Re: Planning Permission Reference AB/88/19/PL

Proposed Non-Material Amendment (NMA) comprising the removal of the approved car port and amendments to the parking layout

Land at Former Gas Works Site, Ford Road, Arundel

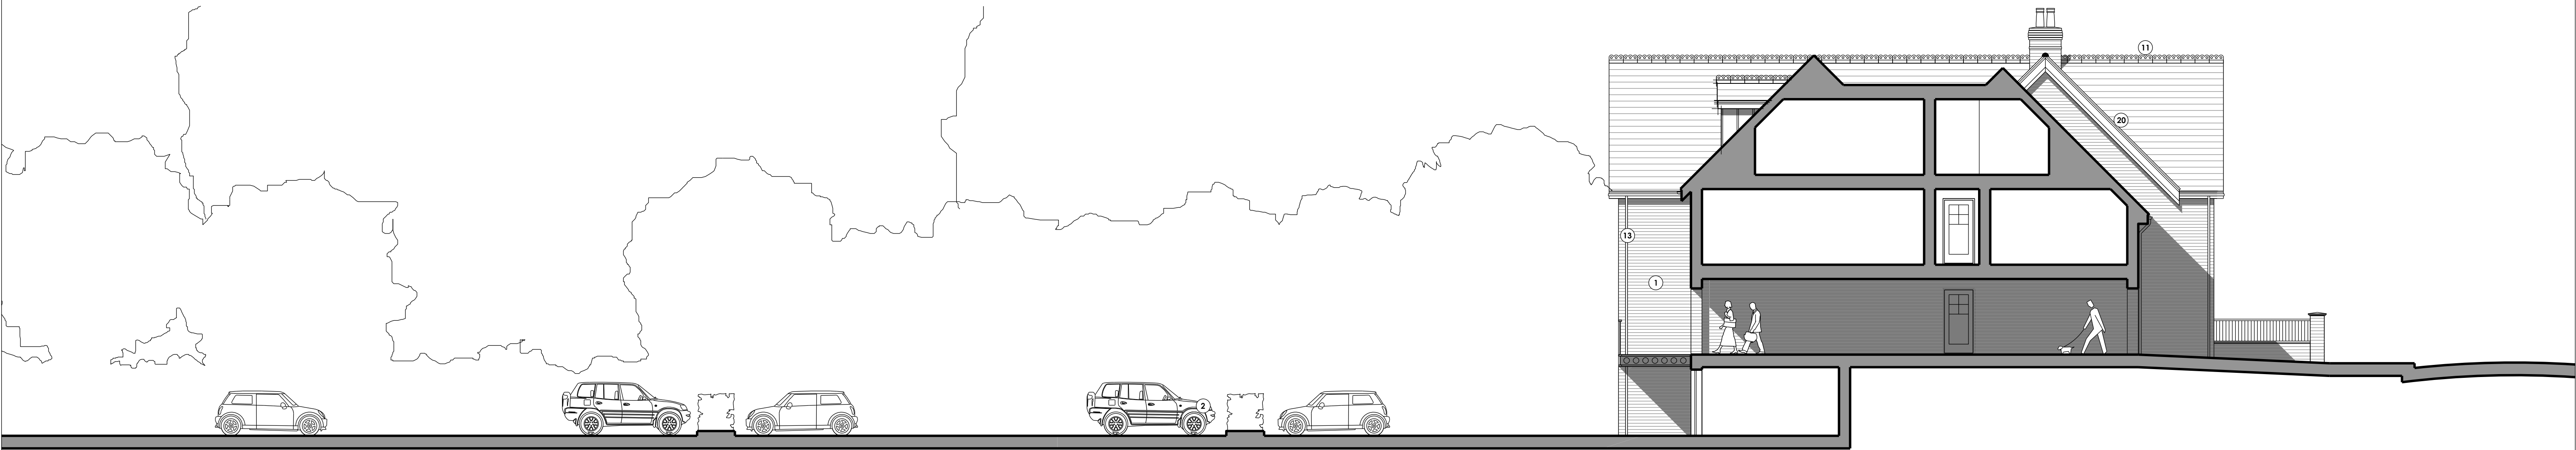
On further review of the approved plans, our client considers it beneficial to remove the permitted car port to the rear of the residential blocks to instead provide additional open parking. It is considered that the car port structure would unnecessarily add to the built form on the site. Its removal would, however, allow additional greater manoeuvrability of cars in and around this part of the site and would enhance natural surveillance.

- Drawing Number PP1249 110-11 P6: South east elevations
- Drawing Number PP1249 110-12 P4: South west elevations
- Drawing Number PP1249 110-13 P5: Section north east and north west elevations
